Ribble Valley Borough Council
Housing & Development Control

Application no: **3/2023/0452**

Address: **Northcote Hotel Northcote Road Langho BB6 8BE**

Proposal: **Proposed construction of single storey pavilion restaurant. Change of use of grazing land to hotel grounds and to facilitate new vehicular access, parking and landscaping.**

Drawing title
 TREE REMOVAL PLAN

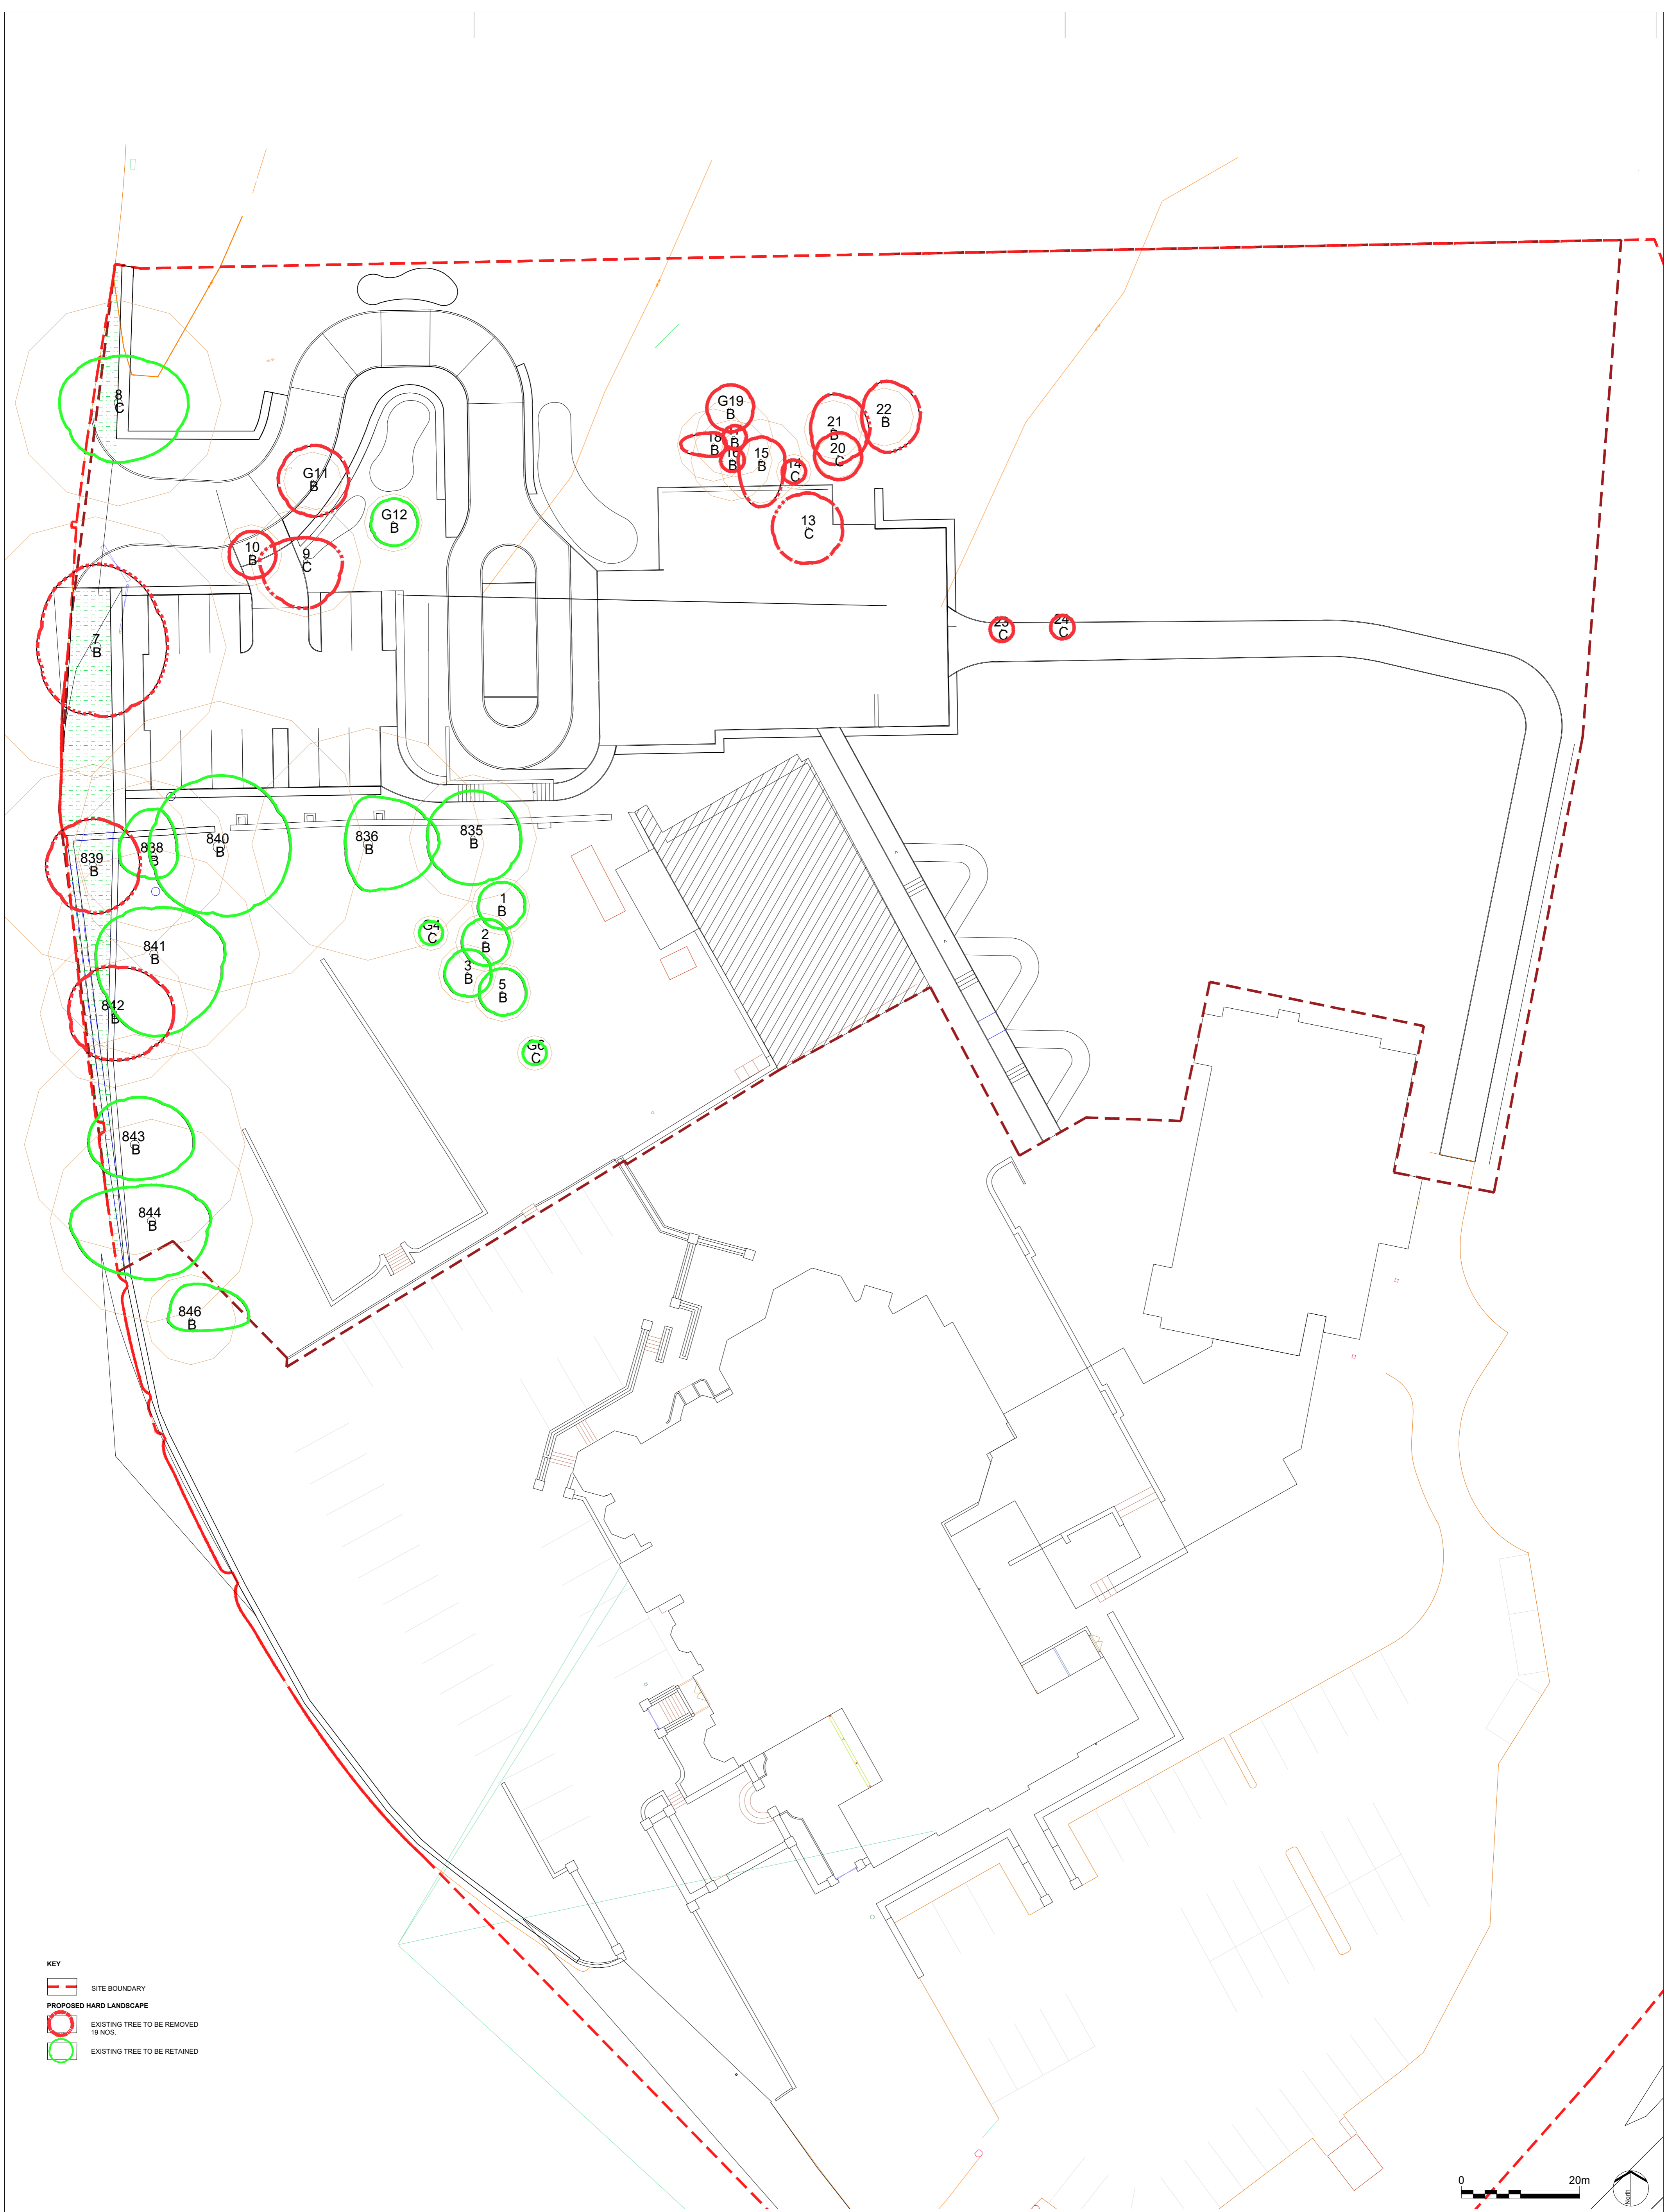
The LHA require that these splays, following the submission of the data to the LHA for validation, are provided on a revised, scaled site access plan. The LHA note that these visibility splays are likely to be achievable following the planned removal of tree 7B, located adjacent to the site access and shown on 3D Reid drawing number 2261-EXA-XX-XX-DR-L-00150 Rev P03 titled "Tree Removal Plan." But a scaled visibility splay drawing is still required to ensure that this is the case.
